Recommendation Report for Planning Permission for Works or Extension to a Dwelling

REF NO: FG/17/22/HH

LOCATION: 44A Ocean Drive
Ferring
BN12 5QP

PROPOSAL: Erection of single storey rear/side extension following the demolition of existing conservatory.

SITE PLAN 1:500 @ A1

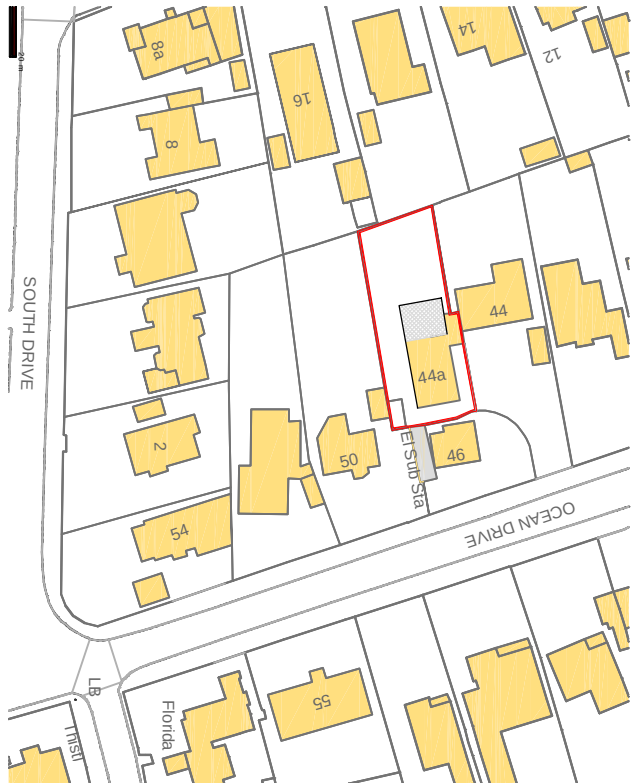
- Site plan does not accurately show the properties curtilage.
- Loss of privacy and noise increase.
- Disruption during construction due to shared driveway.

The site and block plans have been amended to show the correct curtilage.

Proposed Ground Floor Plan

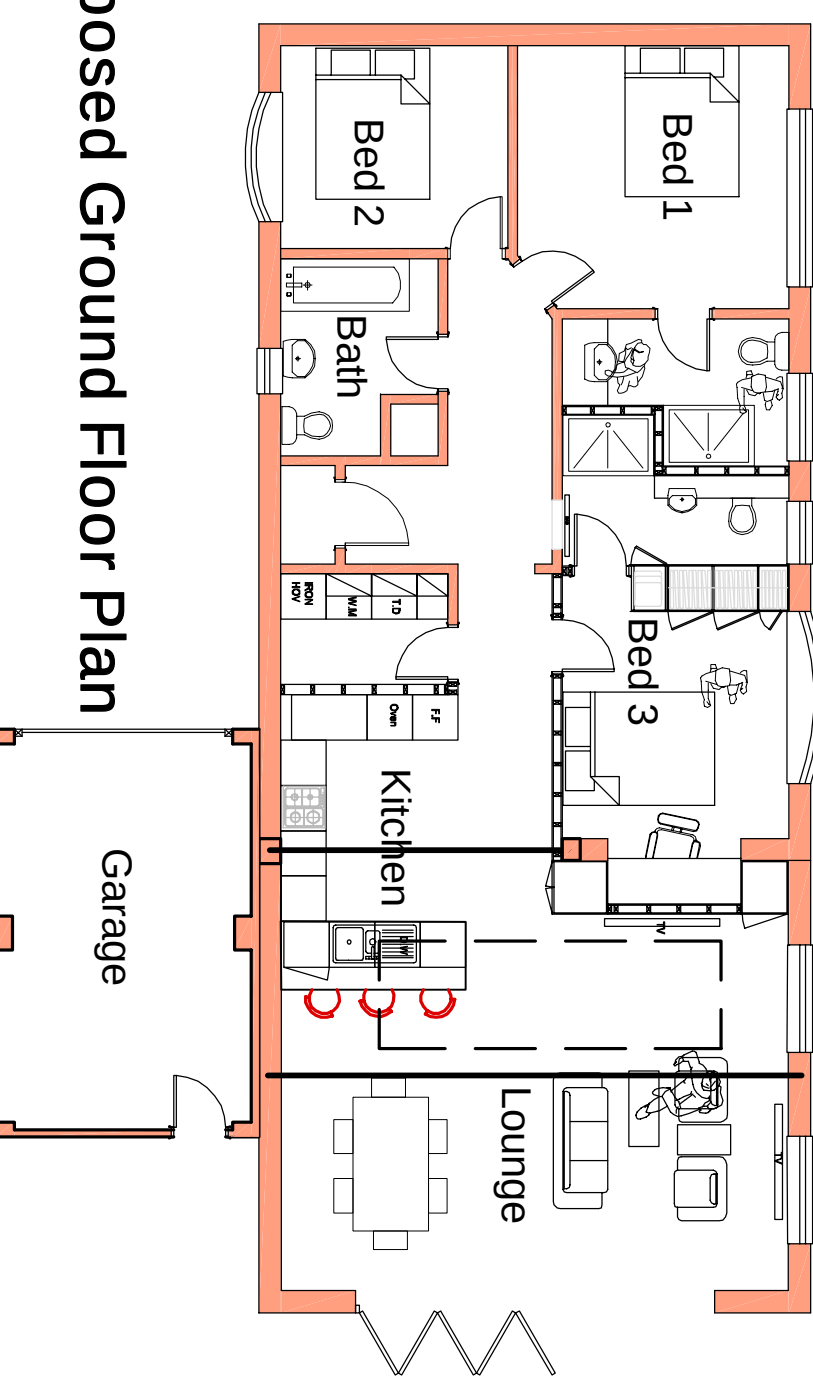
The rear door to the garage is at ground floor and close to the northern site boundary, separated by approx. 0.5m. The northern site boundary is treated by a boundary fence at approx. 1.7m in height. This component is considered permitted development and does not give rise to significantly adverse impacts by way of noise production or overlooking.
